Application: 3/2019/0877

Application Site: Land at Junction of Chatburn Road and Pimlico Link Road

Proposal: Erection of 39 dwellings

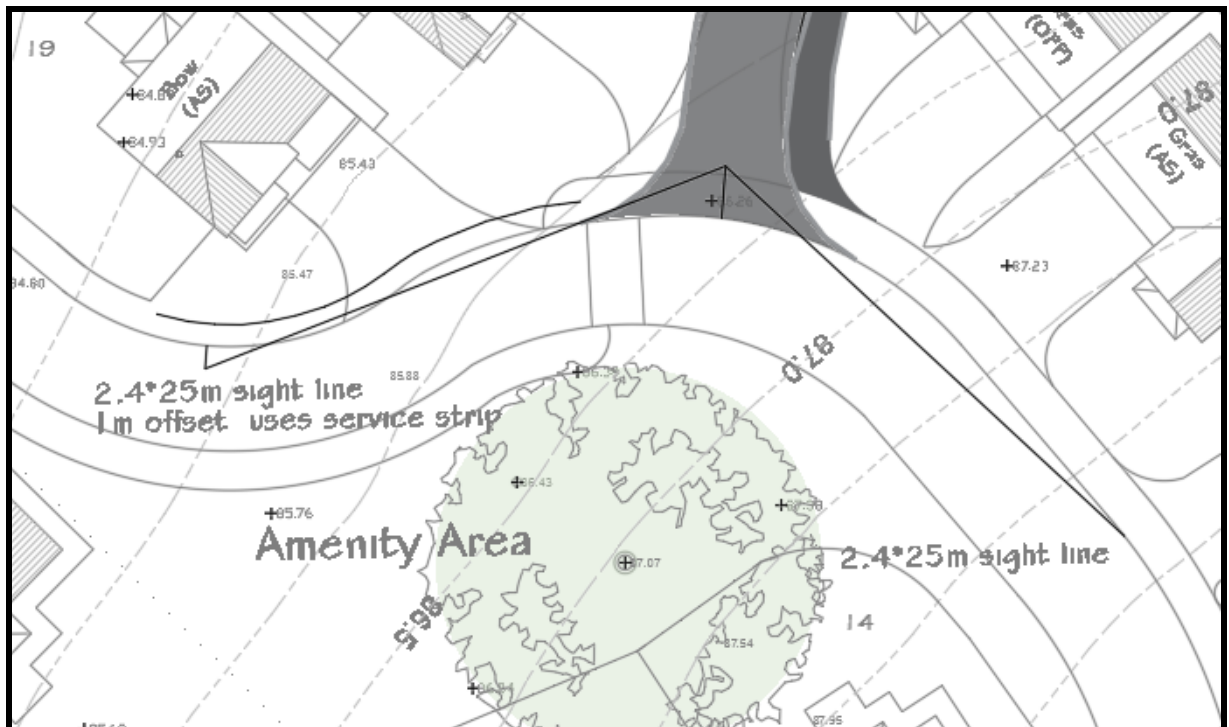
The proposed development has been the subject of discussions with the applicants transport consultant in respect of the transport information provided with the application and the internal layout of the development. These discussions resulted in an amended plan being submitted (Dwg No. 067/P/03 RevB) which is acceptable , taking into account that it is understood from correspondence with the applicants transport consultant that the estate roads within this proposed development will be privately maintained.
